SITE 4B SYDNEY OLYMPIC PARK

ACCESS REVIEW

Morris-Goding Accessibility Consulting

22nd January 2007

Floor Plan
Level 00

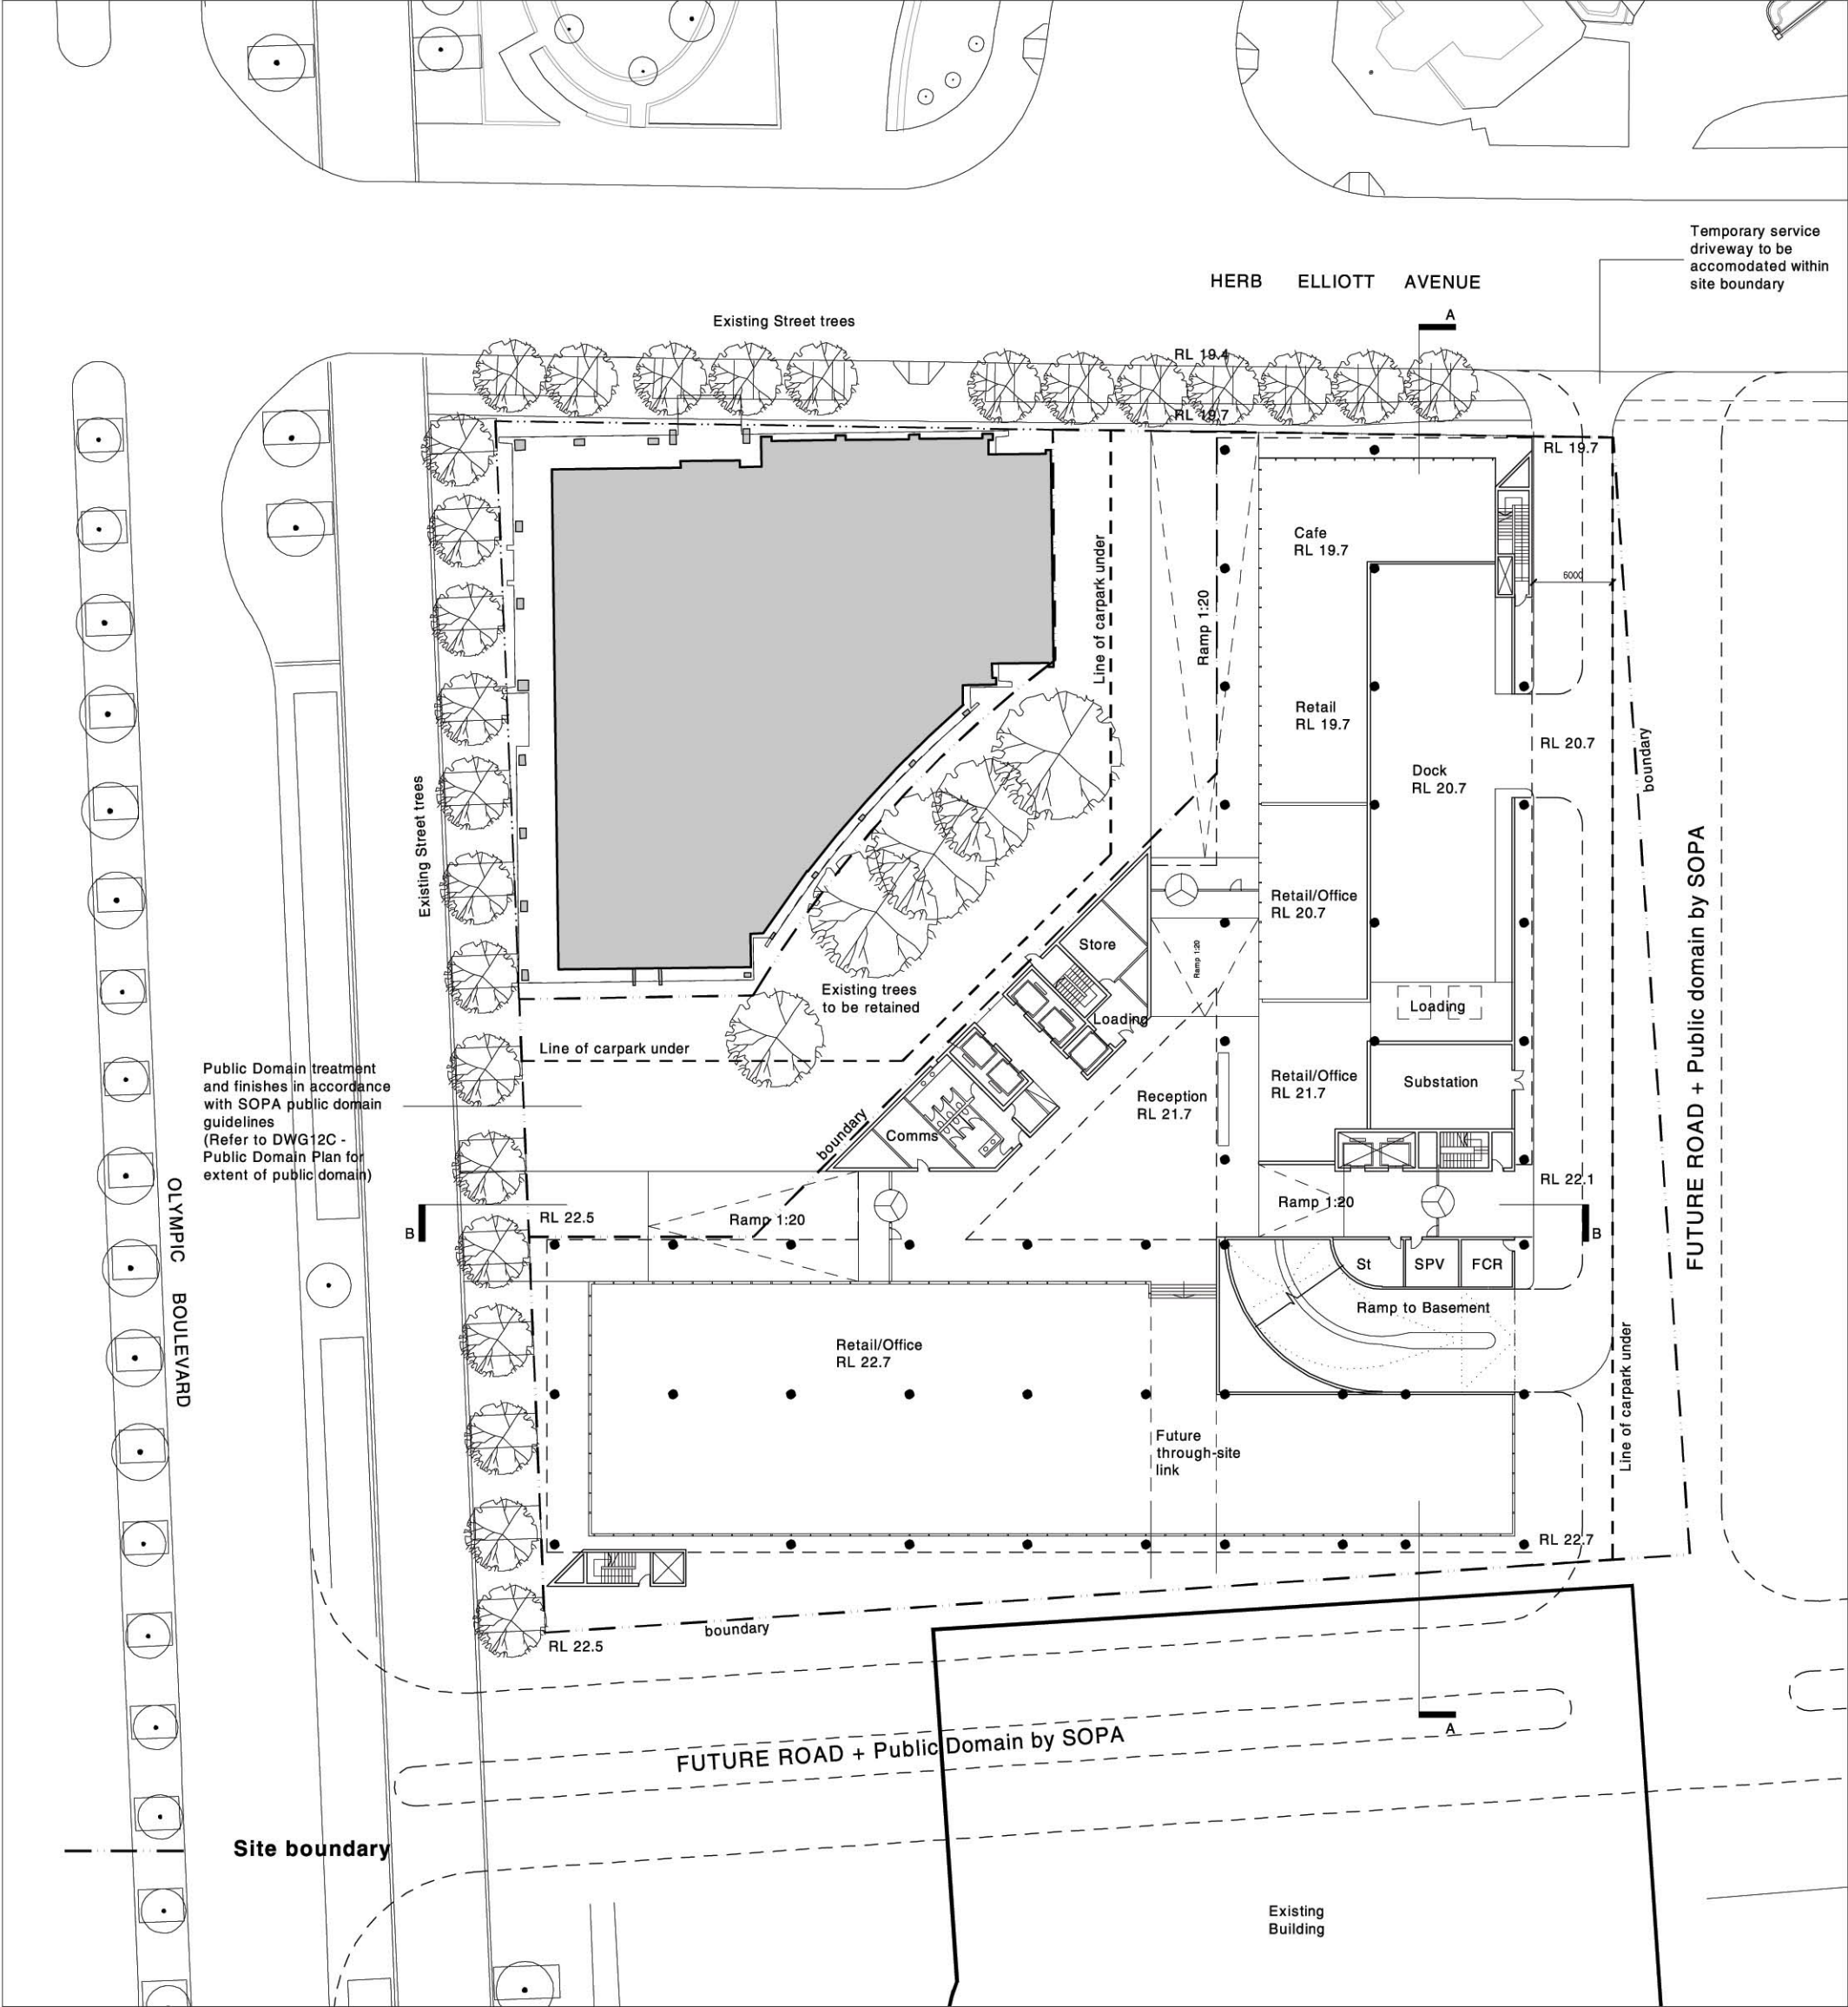
There is a common area (café) on the ground level at the front of the building located adjacent to Herb Elliot Avenue and the entry walkway/ramp. Access to the café is via a continuous accessible path of travel to a double doorway, which is located adjacent the bottom of the entry ramp.

There is also an office area located on the ground floor opposite the lift block. Access into the office is via a 1:14 gradient ramp, compliant with AS1428.1, which then leads to a double doorway.

- (i) The doors to the café at bottom of ramp need to have a landing area of 1:40
- (ii) Ensure ramp leading to office RL22.5 has 1200mm width between handrails.

There appears to be a stair located on the ground floor leading up to the office area RL22.5. There are also sets of steps leading to café on ground floor.

- (i) Ensure there are handrails on both sides of stairs in accordance with AS1428.1.
- (ii) Provide tactile ground indicators at the top and bottom of each stair in accordance with AS1428.4.

Floor Plan
Level 1-6

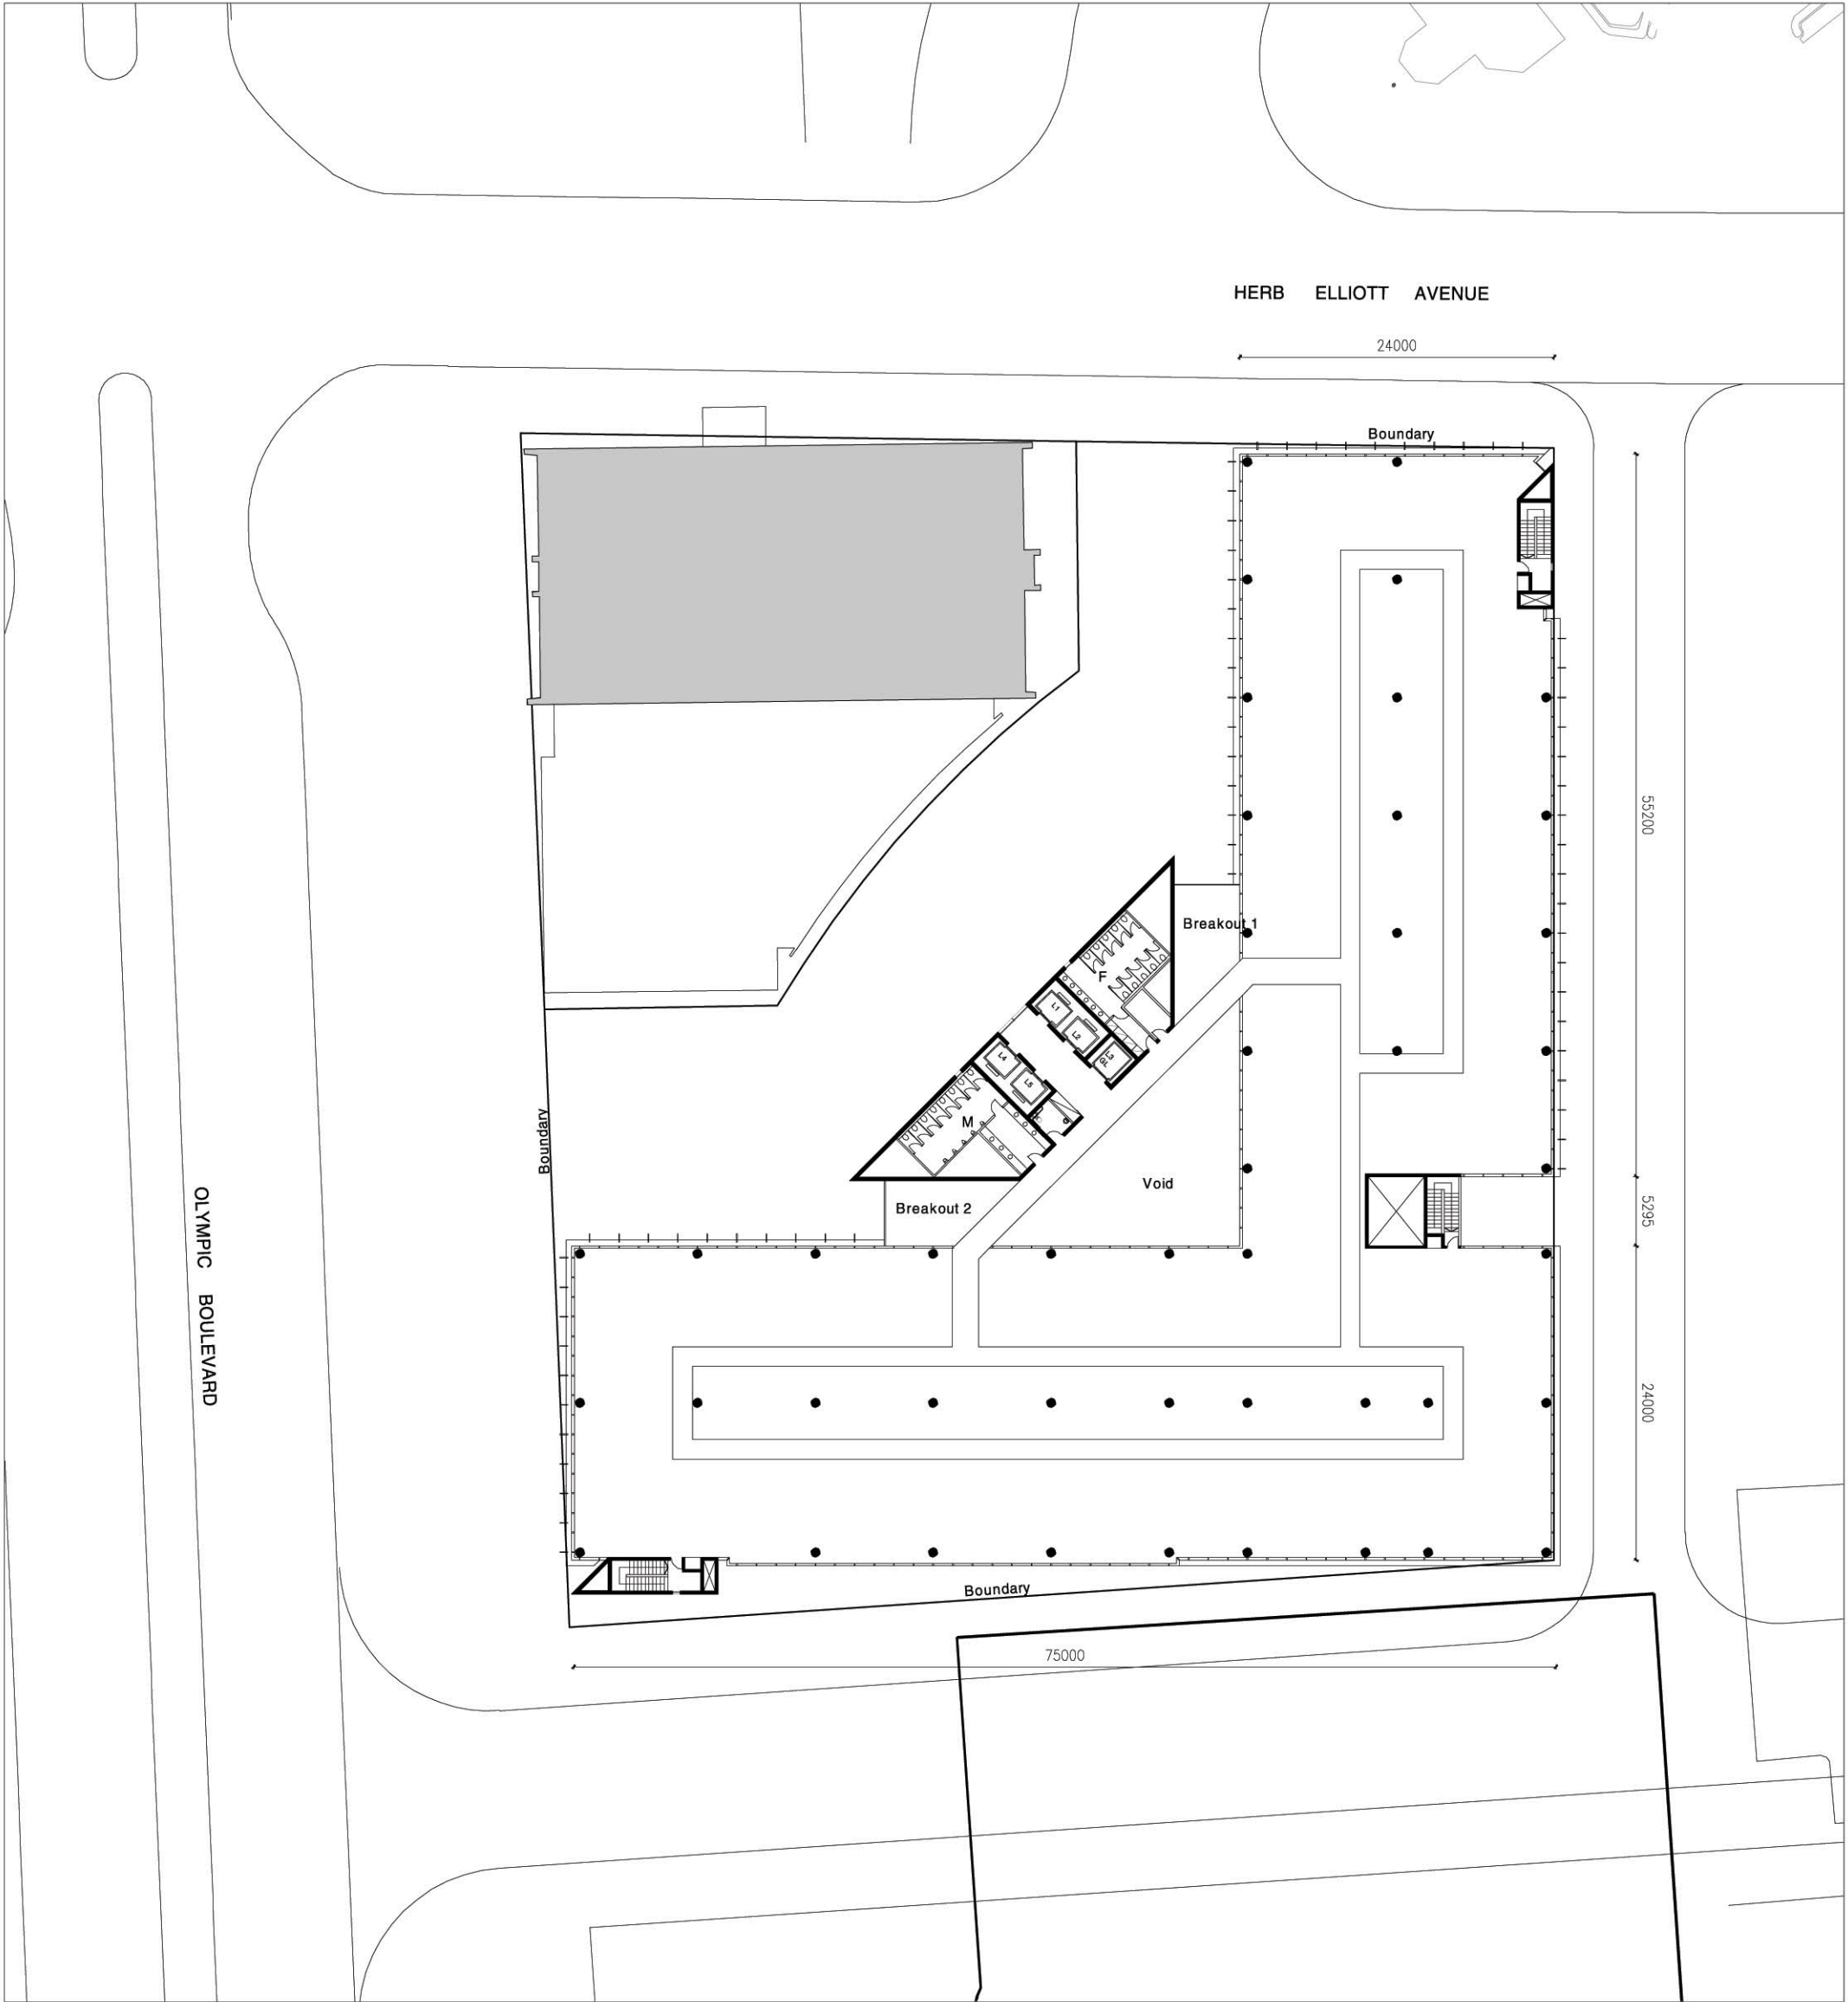
There is a unisex accessible toilet located adjacent to the female toilets on each floor (1-6) of the building. Although the internal dimensions of each toilet comply with AS1428.1 and the SOP Access Guidelines, they do not satisfy the draft DDA standards.

The approach corridors and corridor doors leading to the accessible toilets on each level appear to have circulation areas that do not comply with AS1428.1.

- (i) In order to fully comply with the DDA, consideration to be given to ensure all accessible toilets complies with AS1428.2.
- (ii) Ensure the corridor door leading to the accessible has 470mm latch side clearance (all floors)
- (iii) At least a clearance of 1350mm is required between door swings of the accessible toilet vestibules on each floor.
- (iv) Accessible toilets componentry to comply with AS1428.1.
